WEST SUSSEX COUNTY COUNCIL CONSULTATION

TO:	Arun District Council FAO: A Wood
FROM:	WSCC - Highways Authority
DATE:	18 December 2020
LOCATION:	St. Margarets C Of E Primary School Arundel Road Littlehampton BN16 4LP
SUBJECT:	A/195/20/PL Extension to form a secure lobby to the schools main entrance, along with associated internal alterations.
DATE OF SITE VISIT:	n/a
RECOMMENDATION:	Advice
S106 CONTRIBUTION TOTAL:	n/a

drawing: LOCATION & BLOCK PLANS

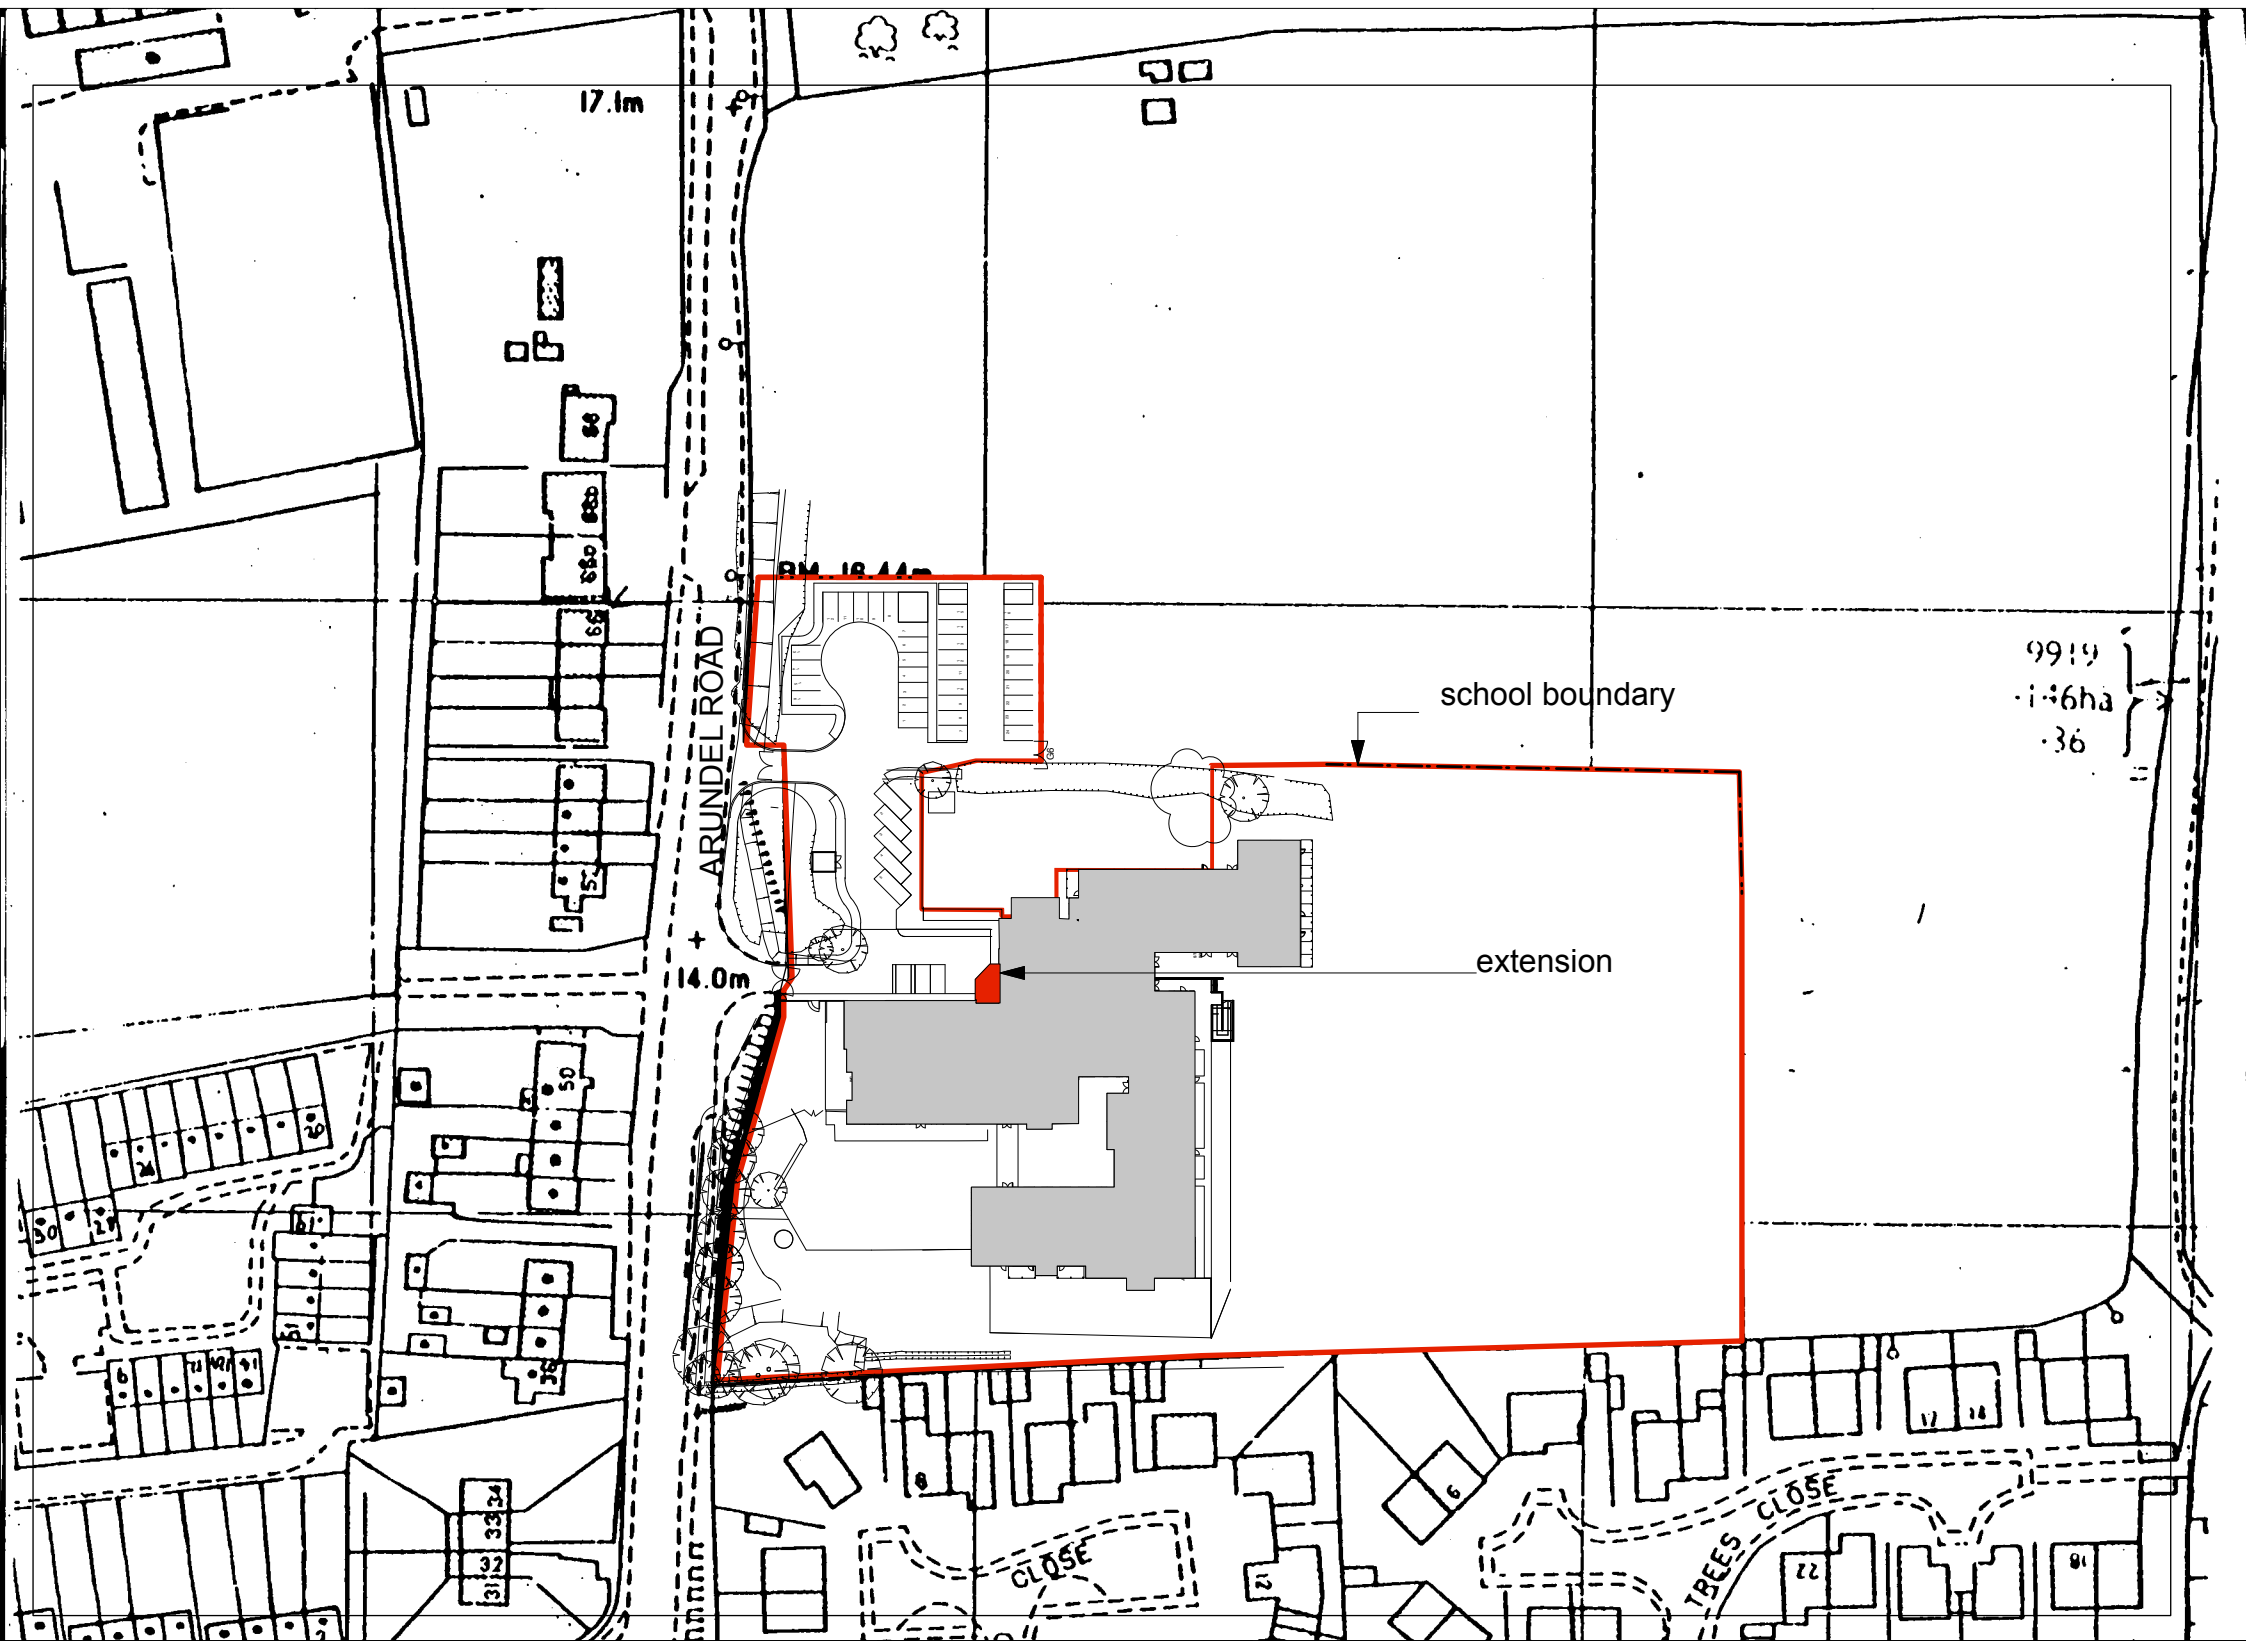
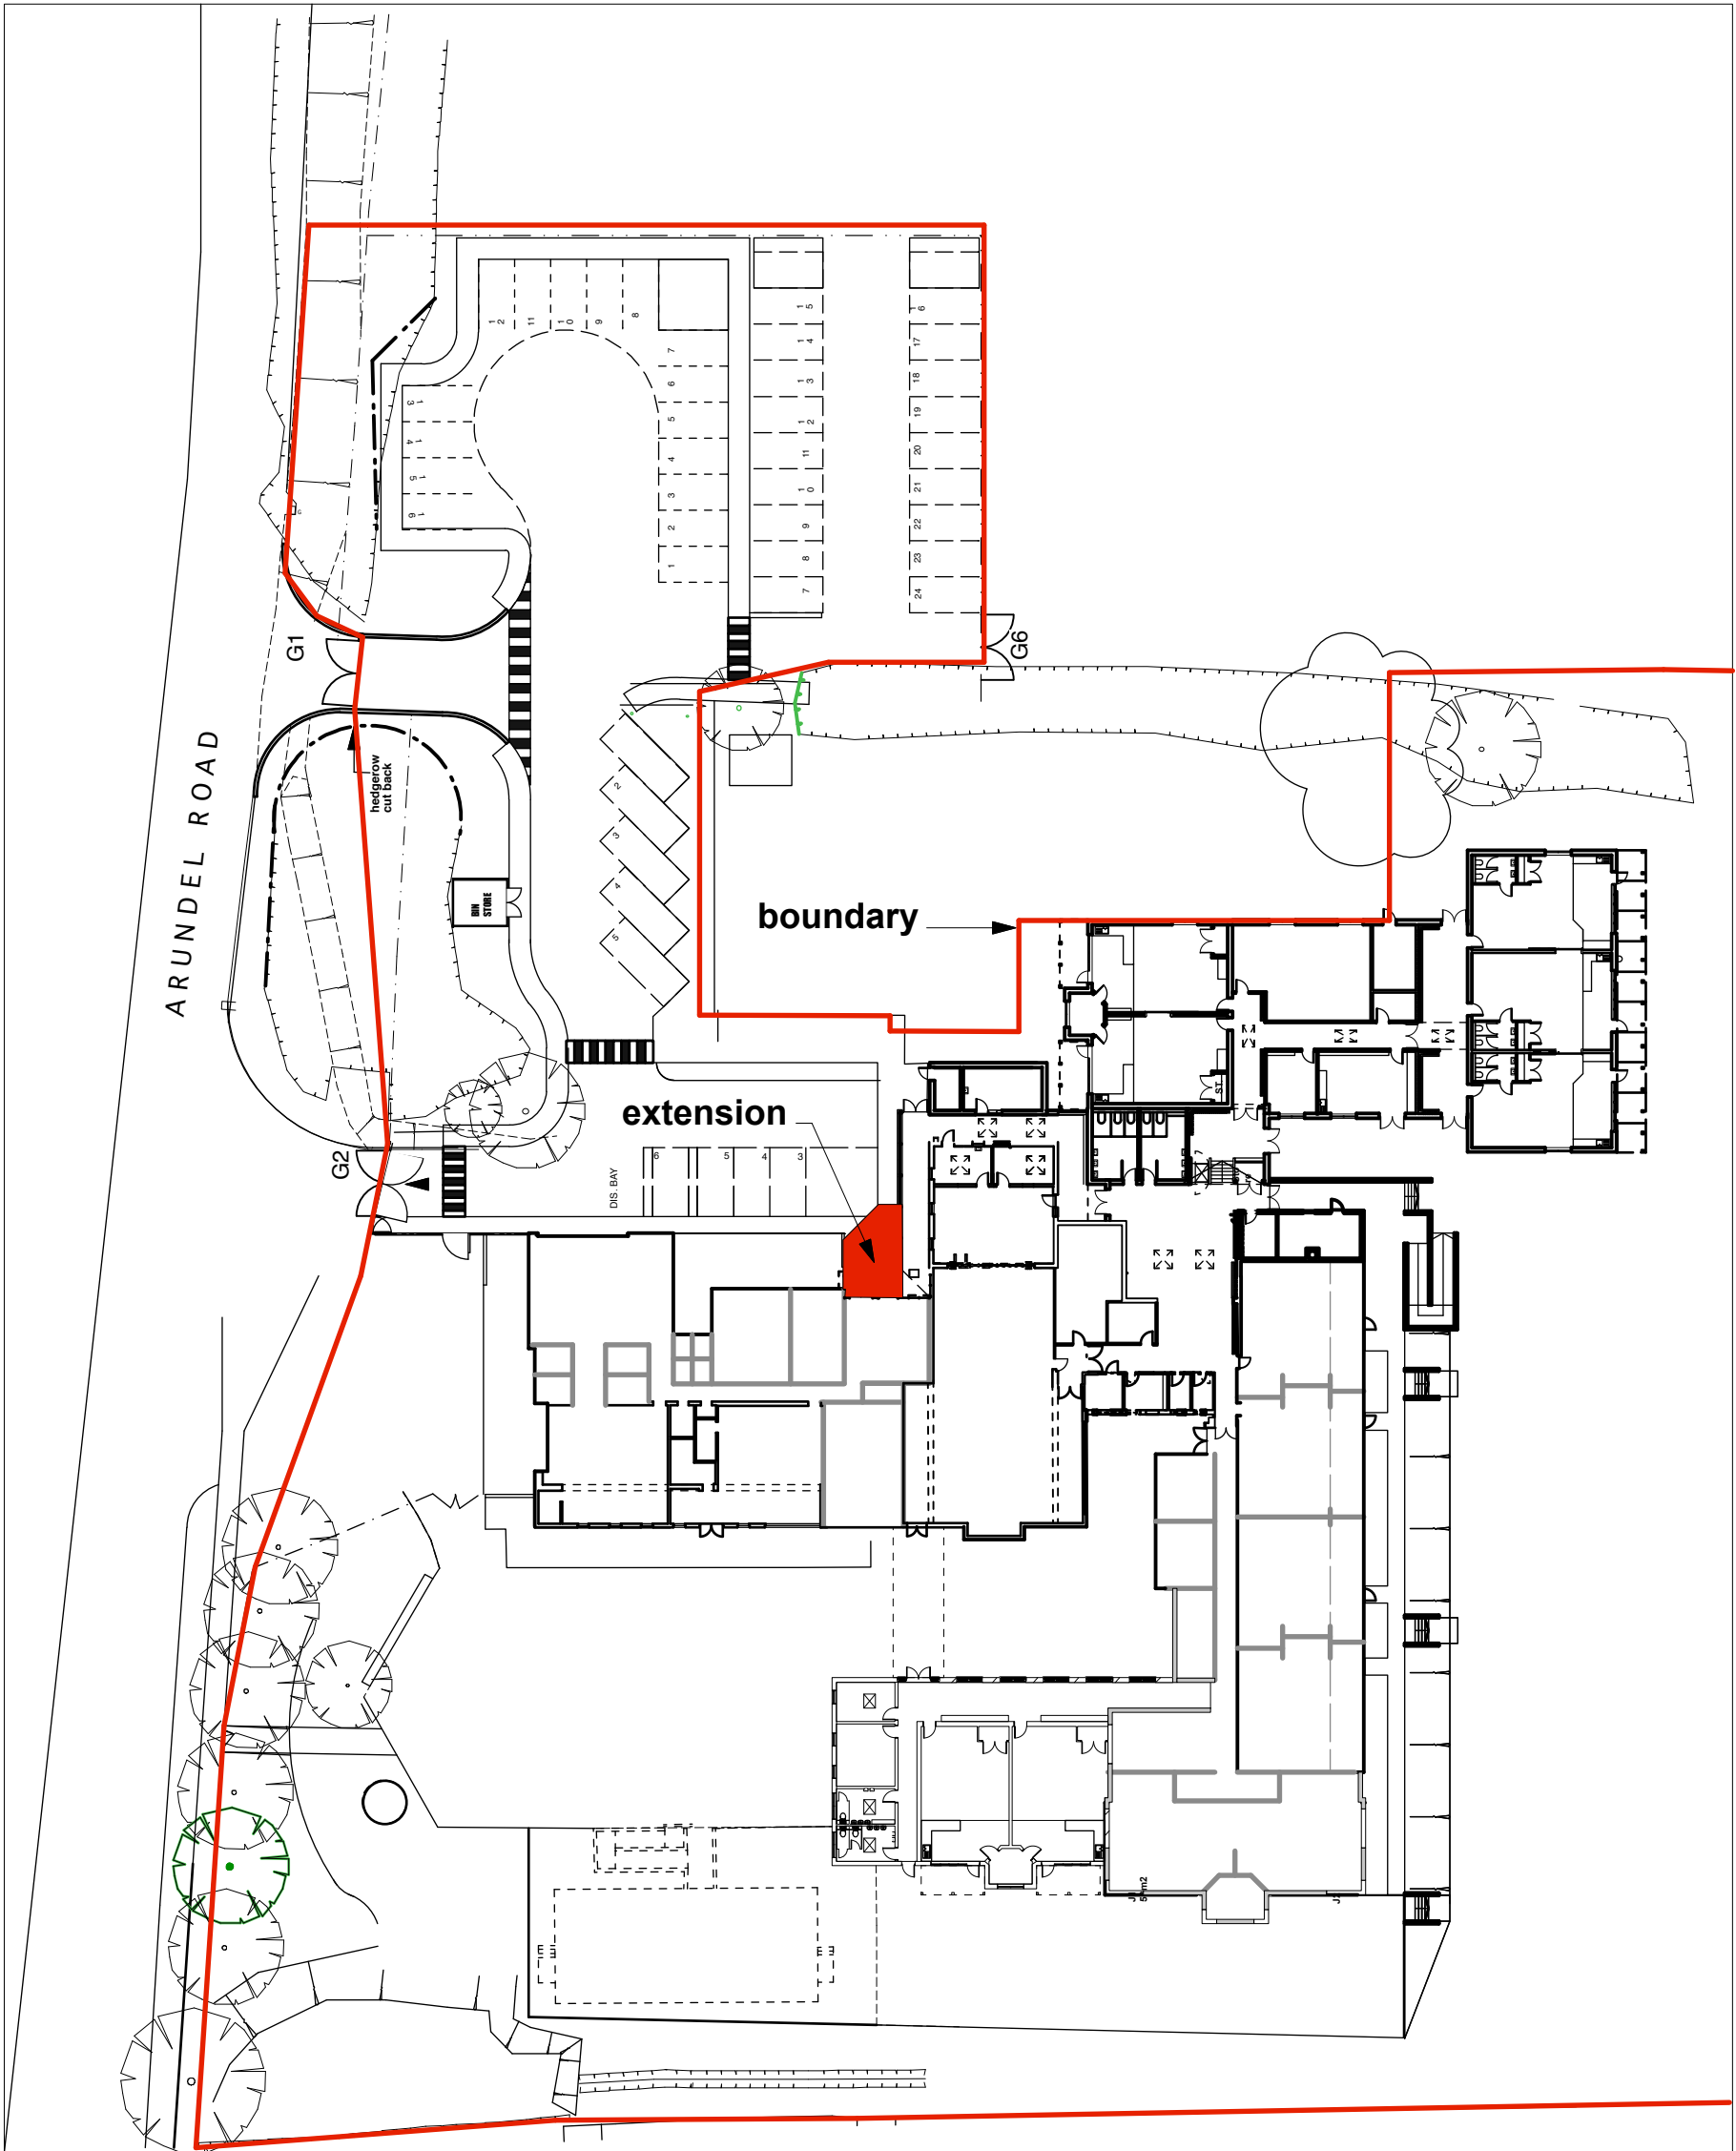
No alterations to the existing vehicle access arrangements are proposed, and no increase in pupil numbers are proposed as part of this application. The provided plan does appear to demonstrate that the existing parking provision will be affected but it is unclear from the Location and Block plan whether this will impact upon 1 or 2 parking spaces.

Currently the site operates with 45 parking spaces and a worst case scenario would be a reduction of parking spaces to 43. The LHA would not raise any highway safety concerns to this proposal but would advise that the LPA consider the potential impact of any overspill parking on on-street parking from an amenity point of view.
